**APPLICATION BY AQUIND LIMITED FOR AN ORDER GRANTING DEVELOPMENT
CONSENT FOR THE AQUIND INTERCONNECTOR PROJECT**

APPLICATION REF: EN020022

**WRITTEN REPRESENTATION OF THE HISTORIC BUILDINGS AND MONUMENTS
COMMISSION FOR ENGLAND (HISTORIC ENGLAND)**

TITLE:
Figure 2b Seabed Features of Archaeological Potential

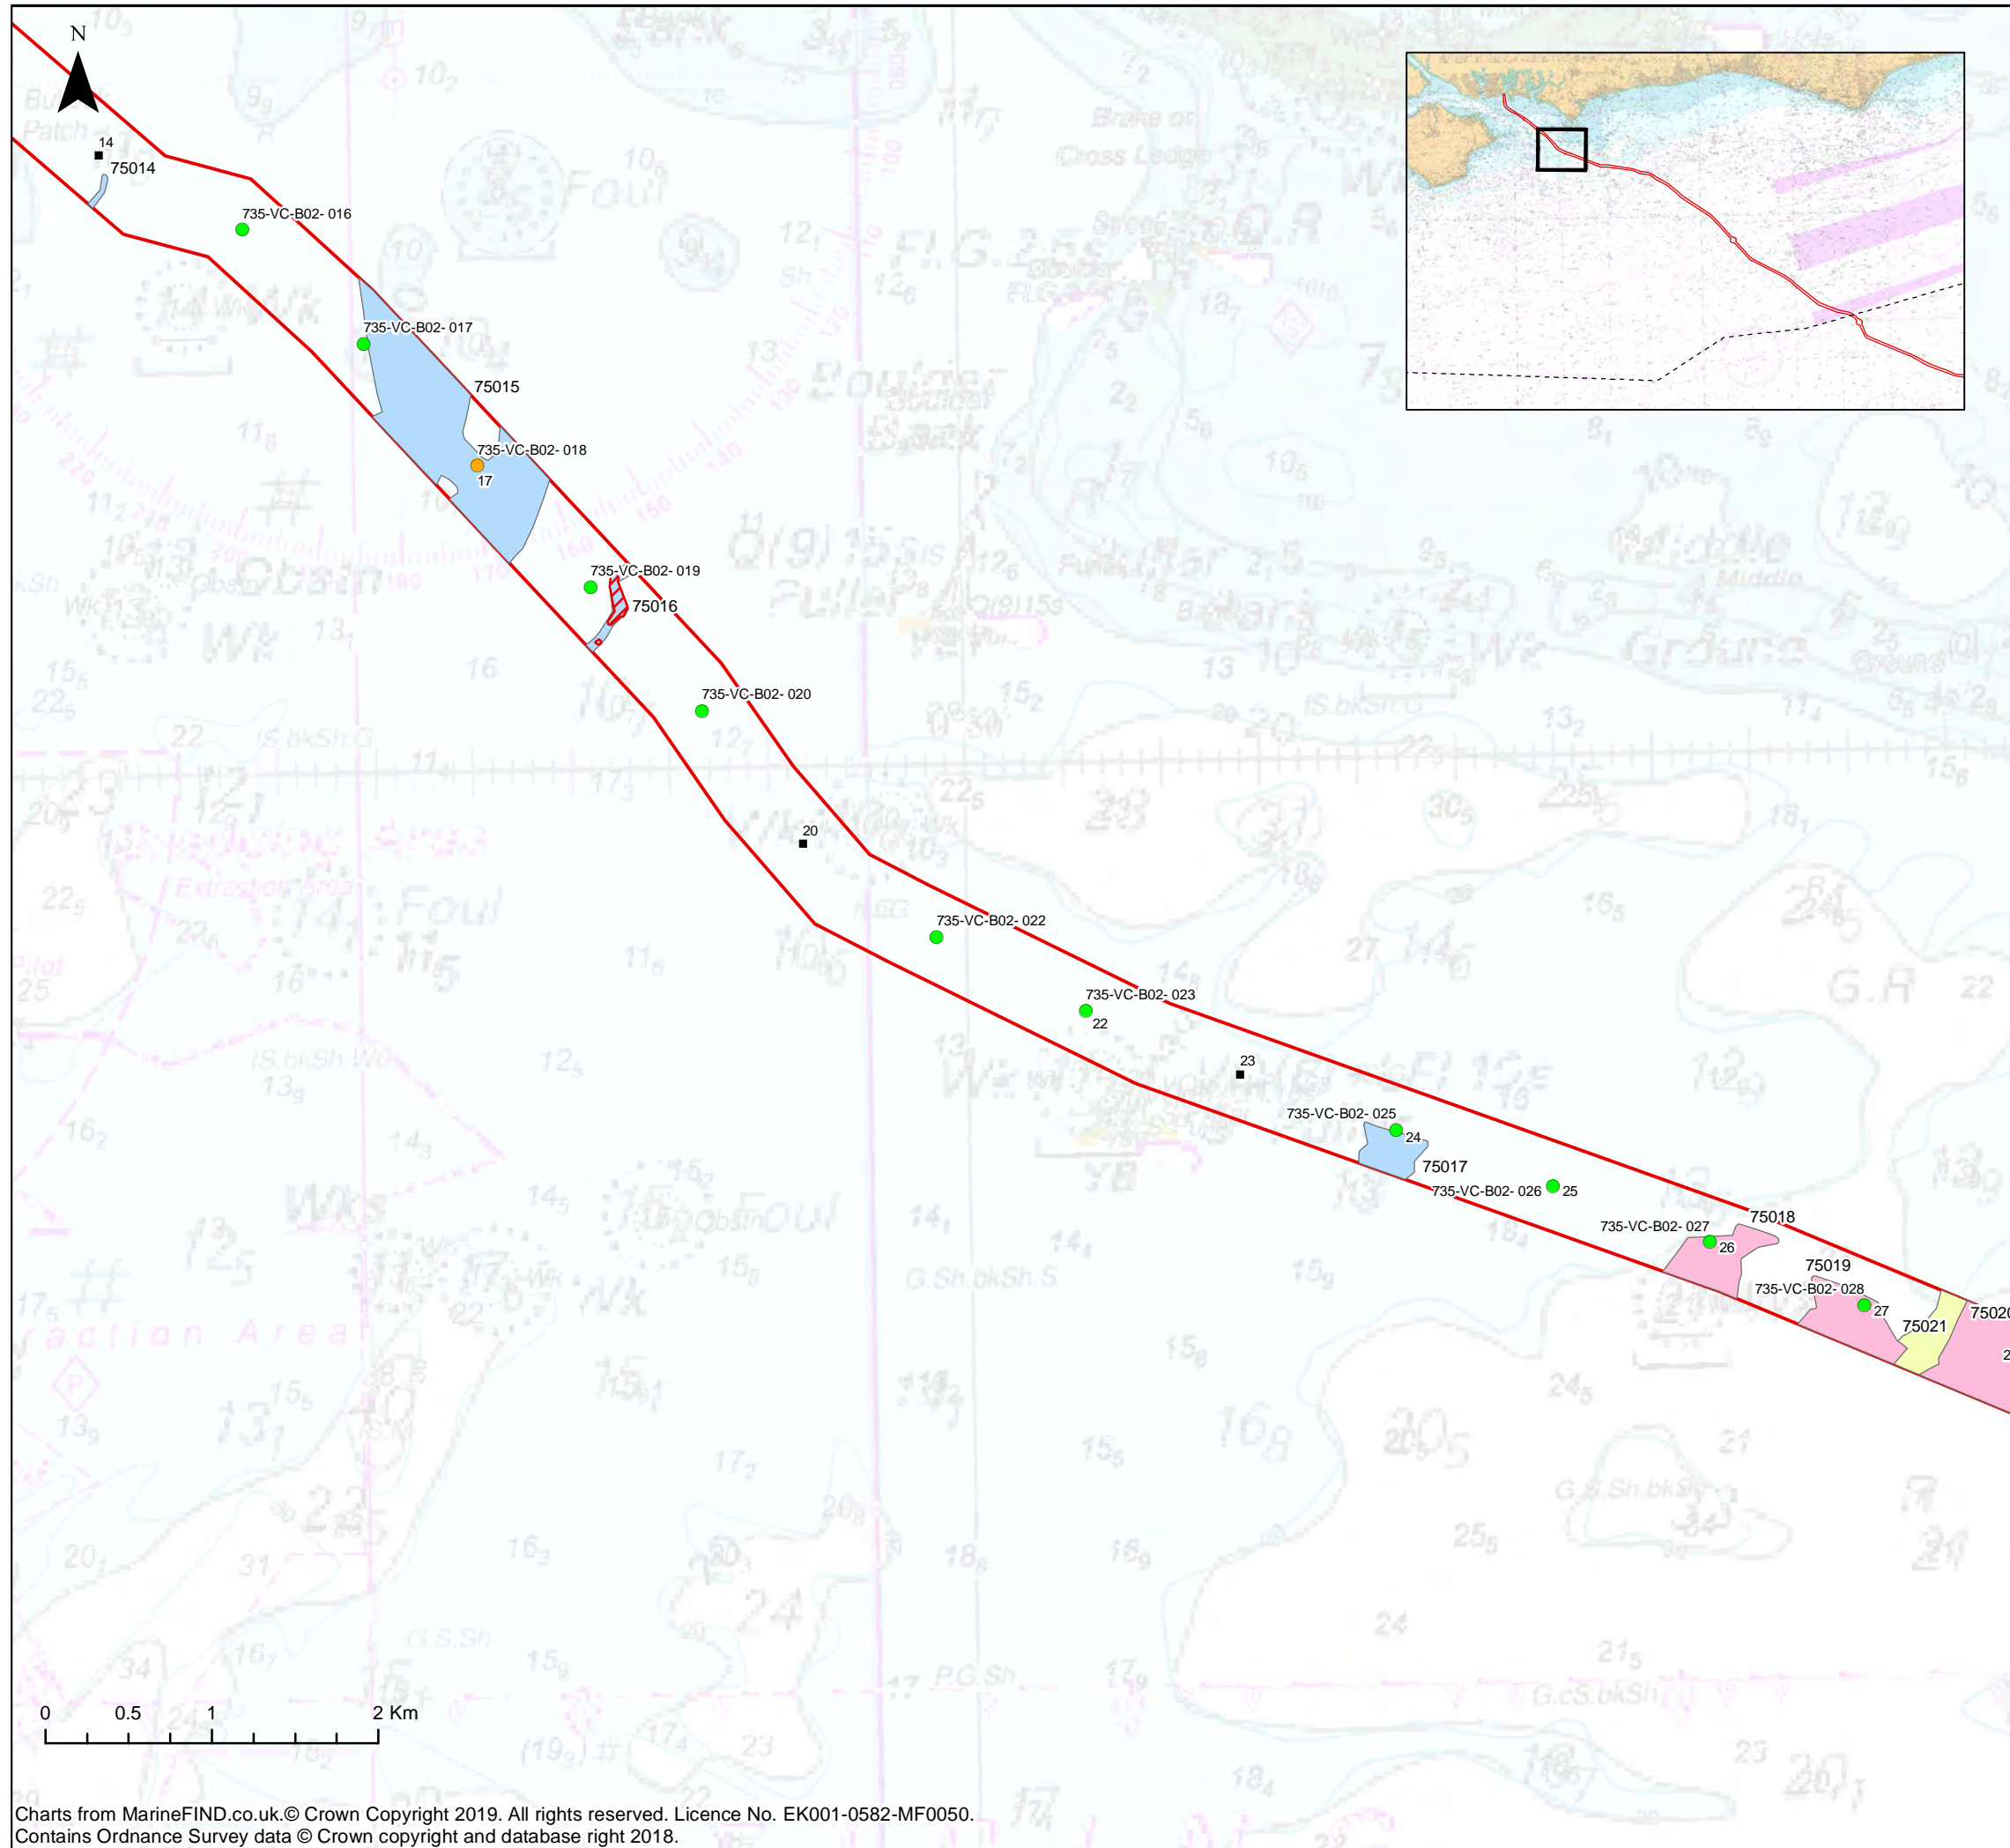
- 3.11 Section 14.8 (proposed mitigation) identifies in Chapter 14, paragraph 14.8.1.2 the “...establishment of appropriately sized AEZs...” specifically focusing on those anomalies identified as “A1”. However, we note in Figure 14.4 that the Archaeological Exclusion Zone (AEZ) identified for anomaly reference 70204

includes “A2” anomaly reference 70205 which are located centrally in the proposed cable corridor. The measures therefore identified within the Marine Archaeological Outline Written Scheme of Investigation (WSI) (Appendix 14.3) for further examination of anomalies will require elaboration within any WSI produced post-consent, should permission be obtained. Such matters are also relevant to any effective micro-siting of the cable route to avoid, where possible, other “A2” anomalies, as described by paragraph 14.8.1.4.
